Application no: H19/1098/93

Description: Retention of dwelling without
complying with landscaping
maintenance condition
(Condition 2 of H19/0179/92)

Location: Chestnut House
239 Broadgate
Sutton St Edmund
Spalding

Landscaping, 239 Broadgate, Sutton St Edmund

SOUTH HOLLAND D.C.
PLAN DEPT.
18 NOV 1993
1098/93

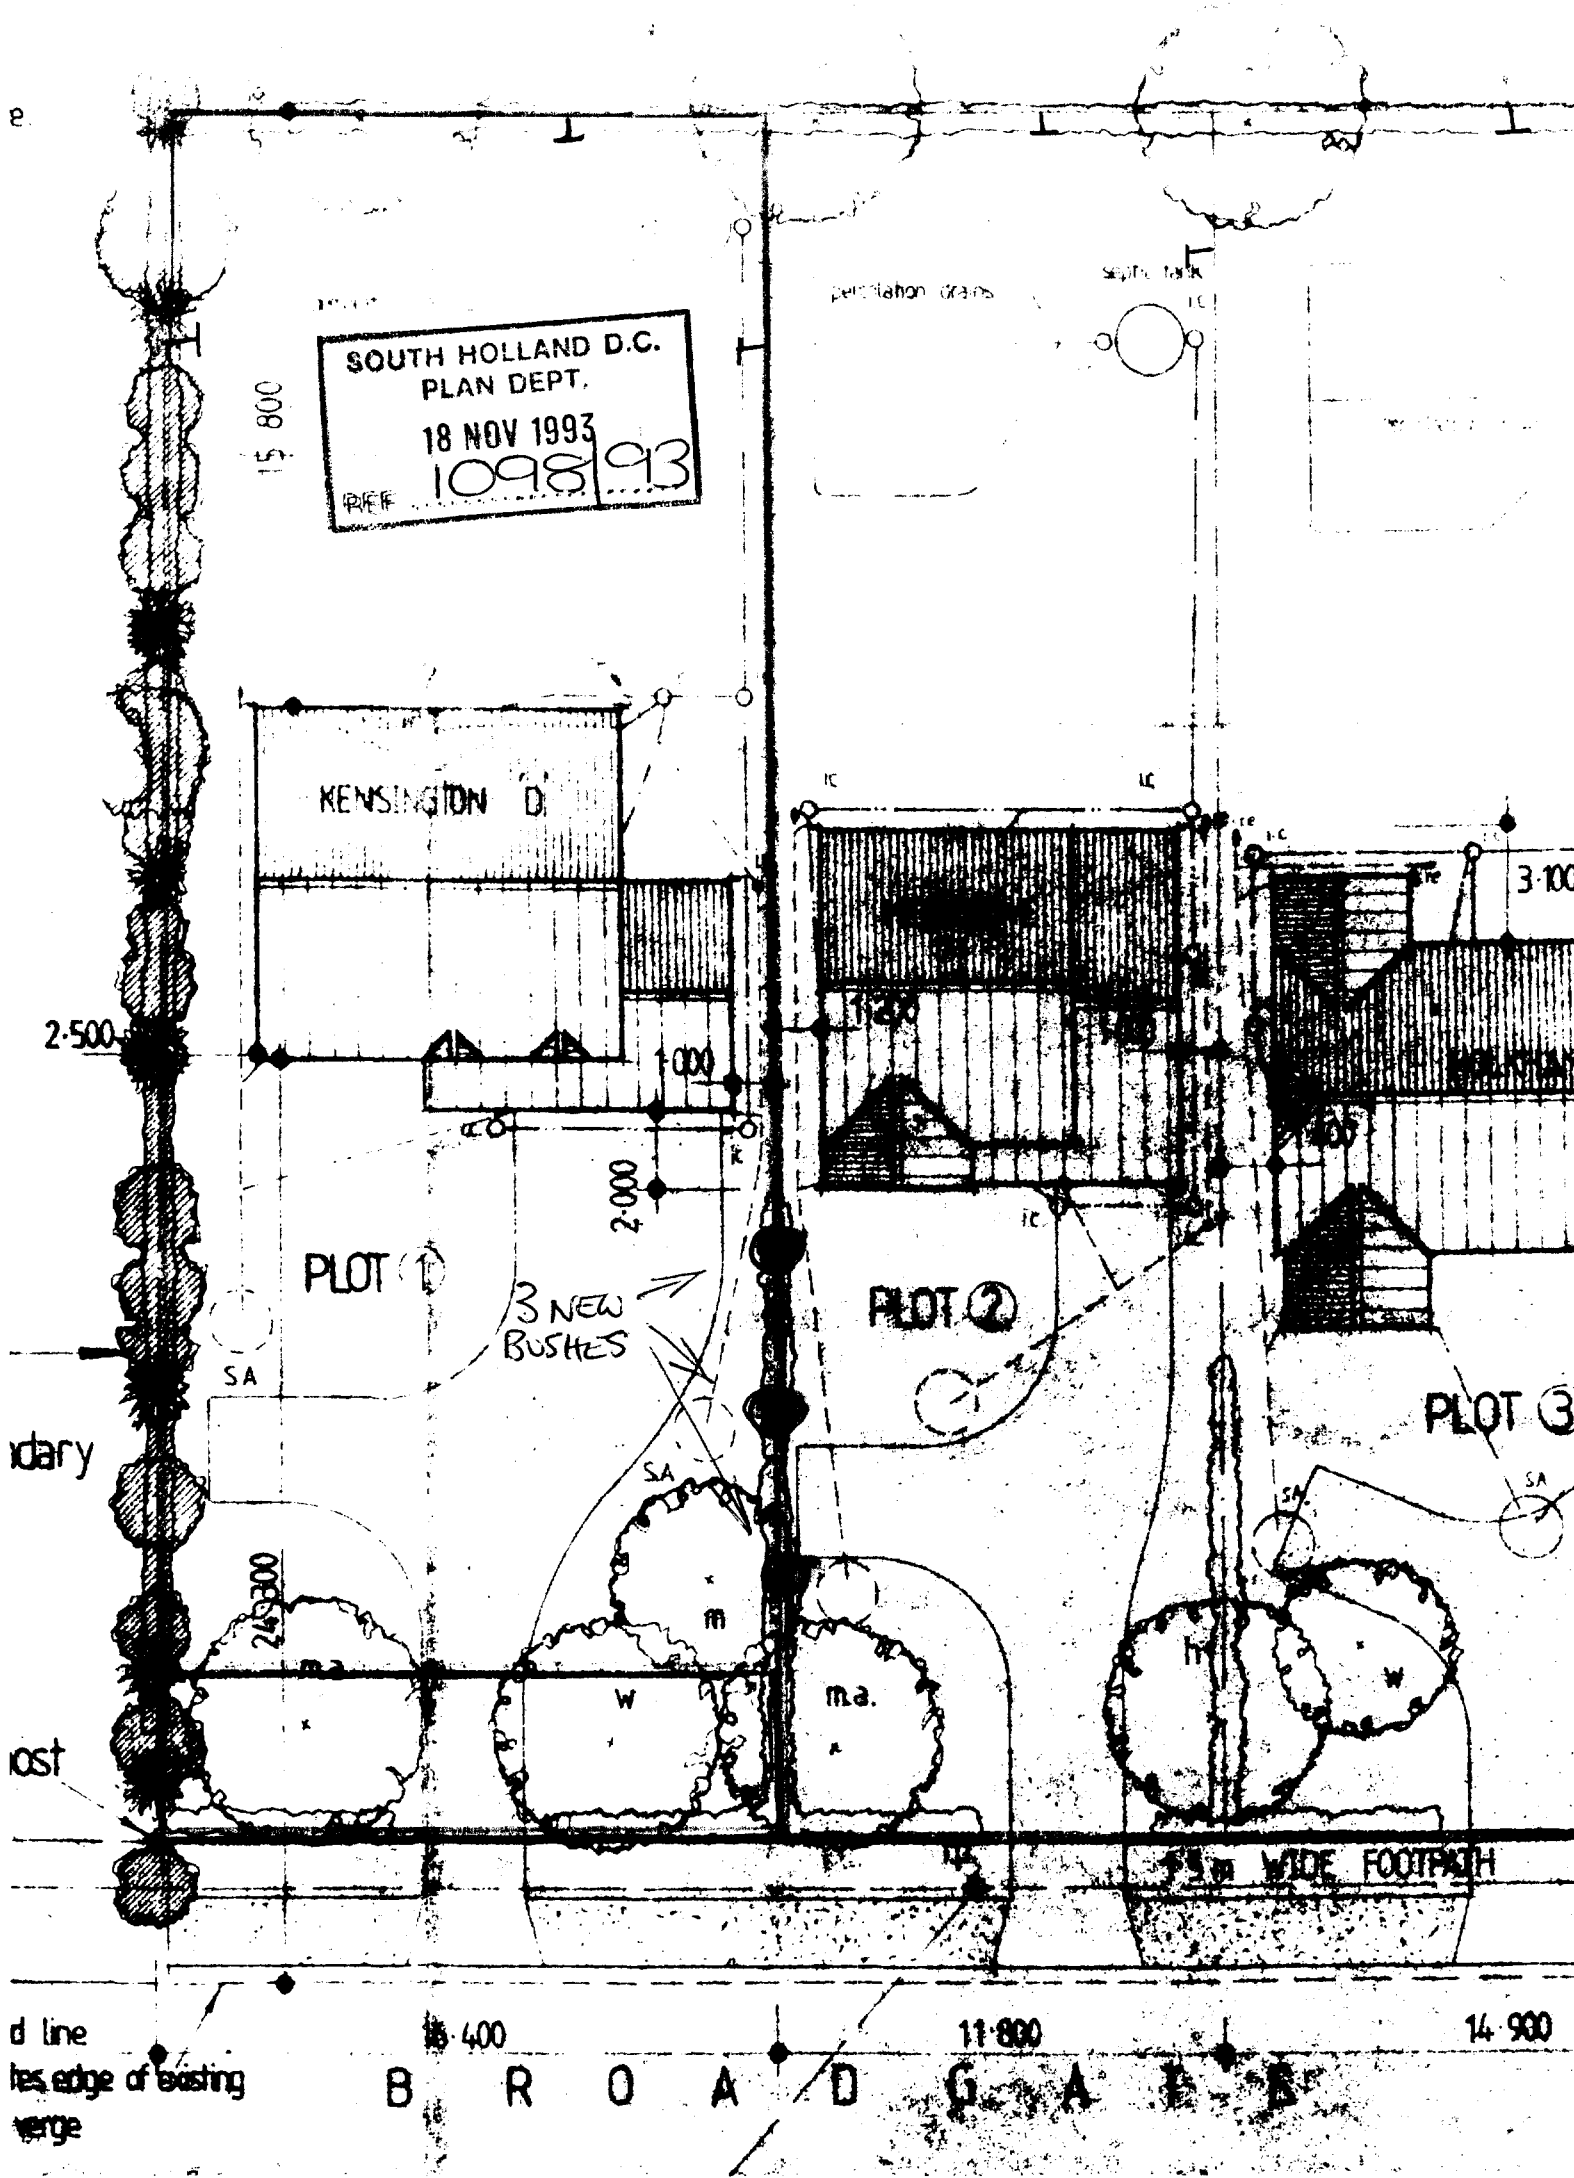
- Assumed condition imposed to ensure that planting species would be sympathetic with local rural area. See no reason

A recent inspection of the site reveals that the hawthorn hedge on the boundary between your plot and that of your neighbours has been removed and replaced with three leylandii plants.

I understand that you are responsible for this particular boundary and the removal of the hawthorn hedge constitutes a breach of a planning condition and I must advise you that the Planning and Compensation Act of 1991 provides the Council the powers to serve a Condition Compliance Notice requiring full compliance with this condition within a set period of time, against which there are no facilities to appeal. The failure to comply with such a notice in the specified time would result in legal proceedings being taken against you.

As explained on the telephone, in an attempt to cut through the procedures which seem to have exaggerated the problem out of all proportion, we are proposing to deal with the different planting as an amendment to the original planning permission. In other words, the changes to the landscaping, in the context of the whole development, are considered to be insignificant and a formal application not therefore necessary.

I will treat your application as a submission of a proposed amendment, and will issue a letter confirming its acceptance.
